# KITITAS COUNTY

## DEPARTMENT OF PUBLIC WORKS

### MEMORANDUM

**TO:** All Staff  
**FROM:** Public Works Plan Review Team  
**DATE:** April 23, 2026  
**SUBJECT:** BL-26-00005 Mattson

**SEGREGATION SURVEY**  
 PREPARED FOR  
 ALCAB ASSOCIATES LLC  
 THE W 1/2 OF THE NW 1/4,  
 SECTION 8, TOWNSHIP 19 N., RANGE 15 E., W.M.

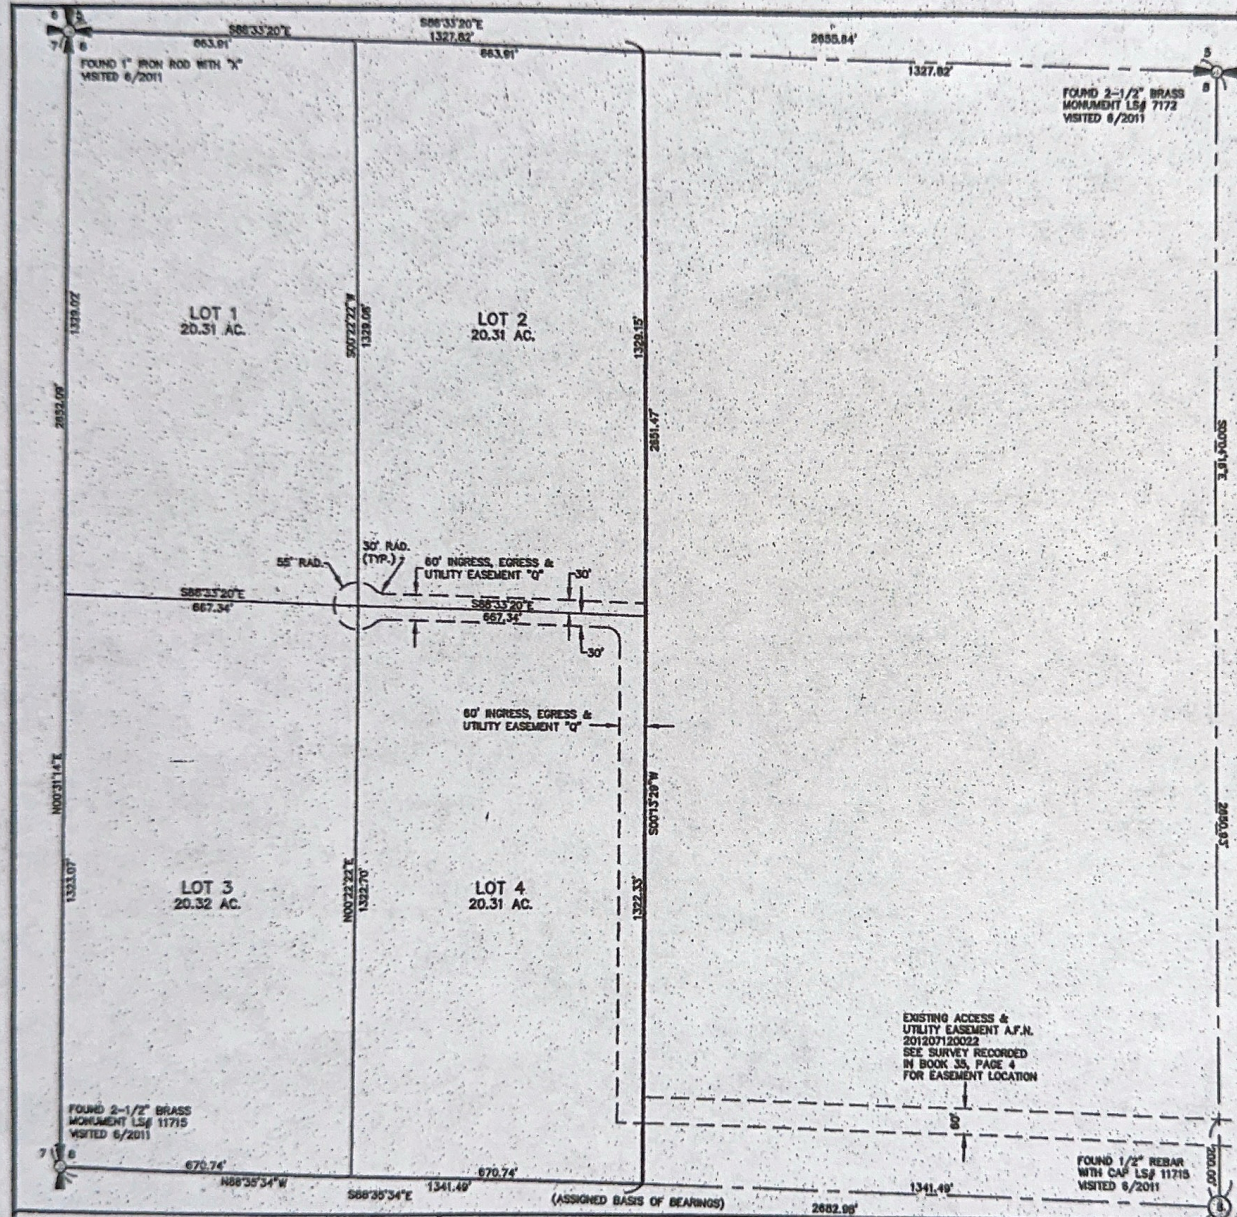
<b>ACCESS</b>	<ol style="list-style-type: none"> <li>1. An approved access permit shall be required from the Kittitas County Department of Public Works prior to creating any new driveway access or altering an existing access.</li> <li>2. RV-18-00010 included construction of private road as shown on the face of Segregation Bk38 Pg32 prior to issuance of a Building Permit.</li> <li>3. Road Certification is required for road serving 4 or more parcels.</li> <li>4. Road shall be named according to the Kittitas County Private Road Naming and Signing Standards.</li> <li>5. Maintenance of driveway approaches shall be the responsibility of the owner whose property they serve. The County will not maintain accesses.</li> <li>6. Any further subdivision or lots to be served by proposed access may result in further access requirements. See Kittitas County Road Standards.</li> </ol> <p>In addition to the above-mentioned conditions, all applicable Kittitas County Road Standards apply to this proposal. Access is not guaranteed to any existing or created parcel on this application. (RC)</p>
